<b>Application Ref:</b>	2025/0980			 Ribble Valley Borough Council <a href="http://www.ribblevalley.gov.uk">www.ribblevalley.gov.uk</a>				
<b>Date Inspected:</b>	17/02/2026	<b>Site Notice:</b>	N/A					
<b>Officer:</b>	EP							
<b>DELEGATED ITEM FILE REPORT:</b>					<b>APPROVAL</b>

<b>Development Description:</b>	Regularisation of conversion of garage to living space with new window and door.
<b>Site Address/Location:</b>	33 Shipton Road Clitheroe BB7 2RZ

Scale 1 - 100 Proposed Drawings

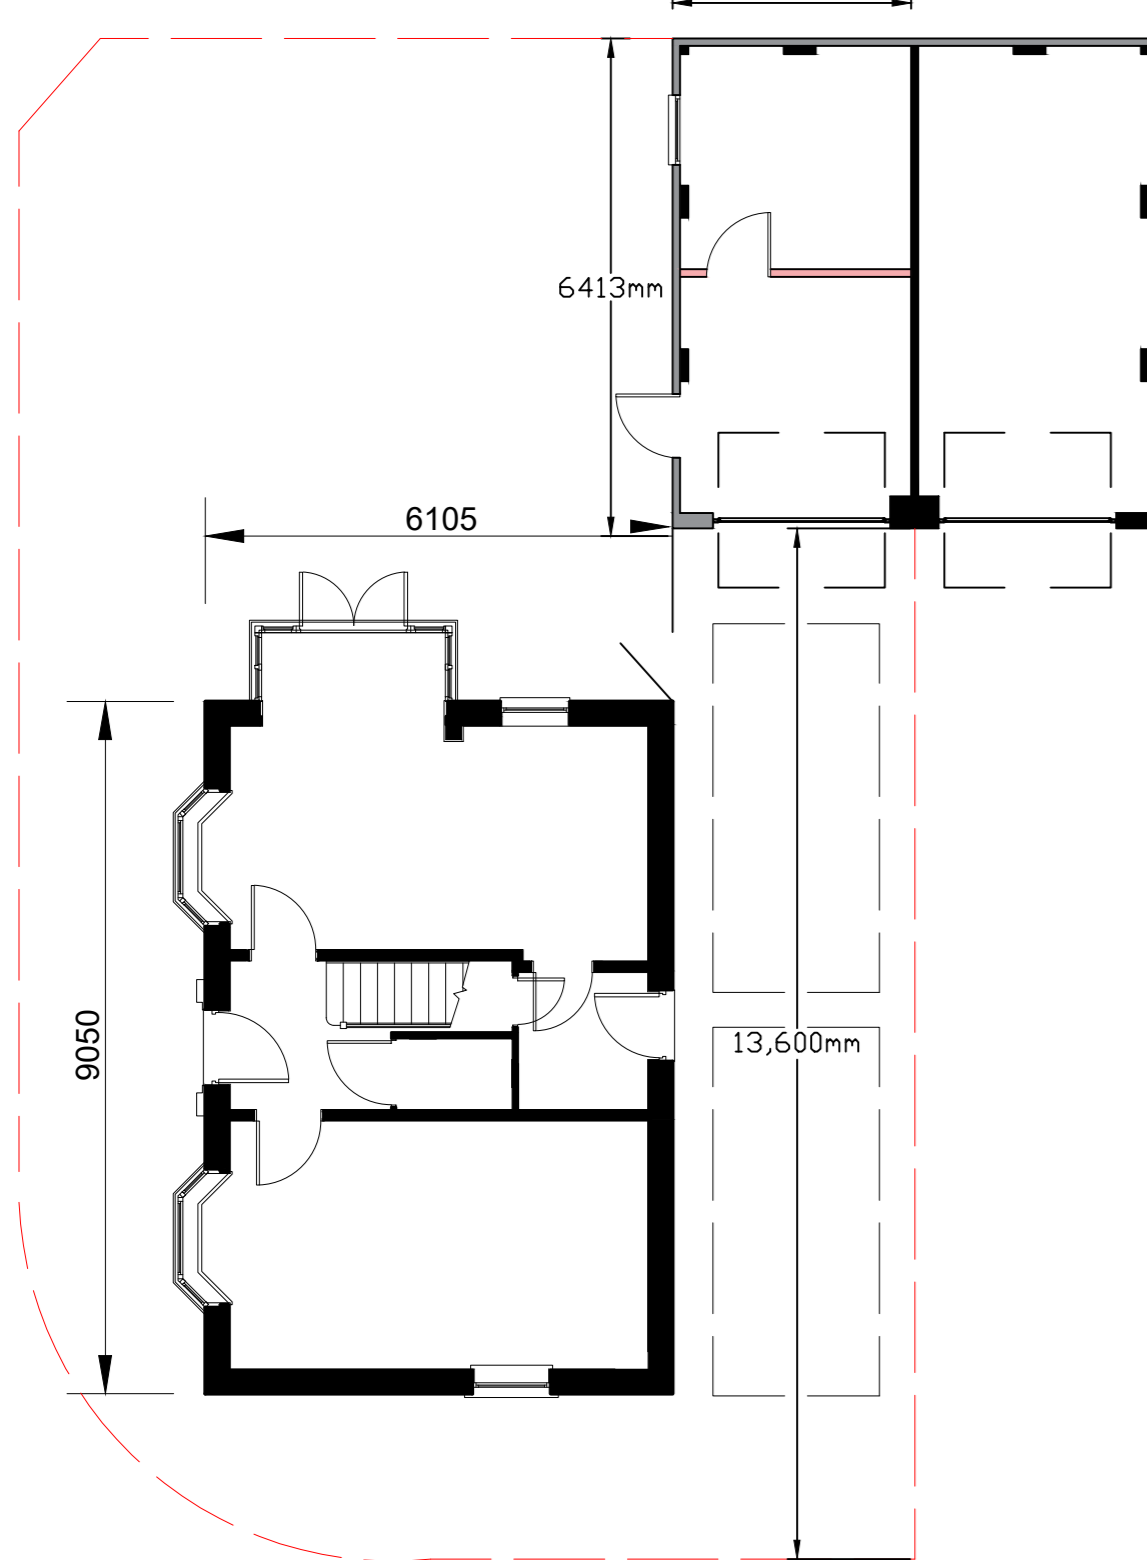
It has been recognised that, as a result of the development, there will be a loss of 1 parking space at the site. In this instance, there is no space within the existing site boundary to accommodate an additional parking space following this loss. As such, there will be a shortfall of 1 parking space as required by parking standards which stipulates there should be 3 off-road parking spaces for a 4 bedroomed dwelling. However, given the site is in a relatively suitable location, it is considered that this issue alone would not justify refusal of the application given the lack of any objection from LCC Highways. In this instance the shortfall could be offset by the addition of cycle storage which can be achieved via relevant planning condition.

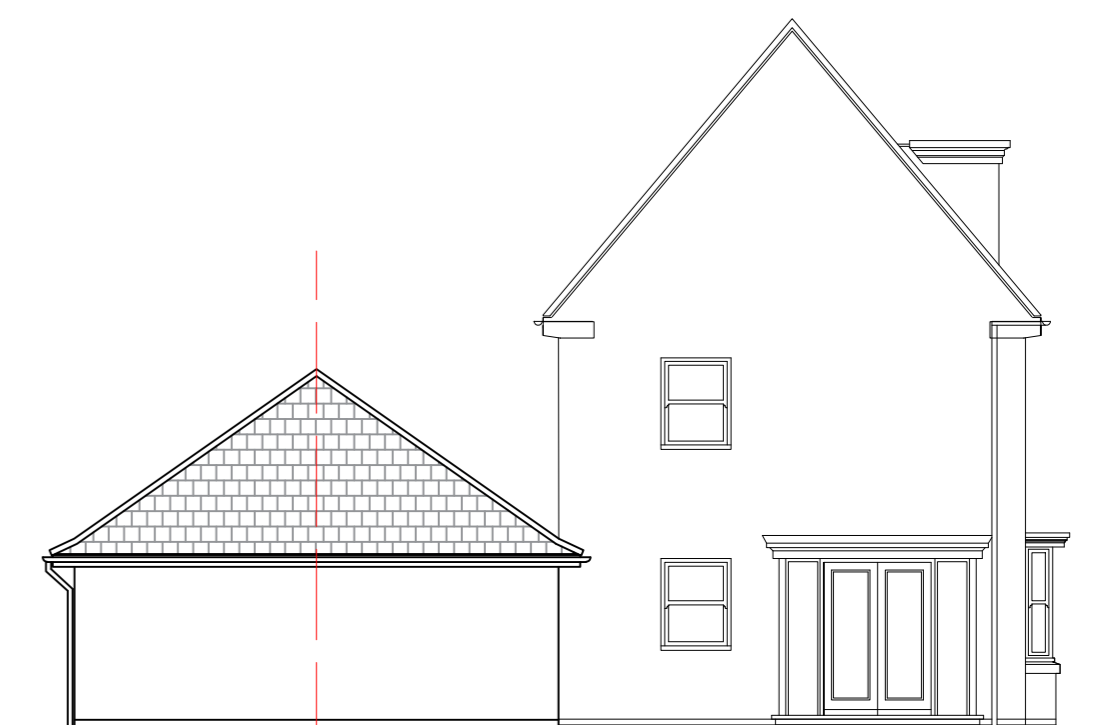
There is a new window and door opening proposed in the western elevation of the garage. These will provide views solely of the application dwellings residential curtilage. As such, no loss of privacy is expected resultant.

The existing garage door will be retained and therefore from the principal elevation of the structure there will be no visual change. The new window and door proposed in the western elevation will be screened from view by virtue of the existing boundary wall at the site. As such, the proposal will have no adverse impact on the visual amenity of the area.
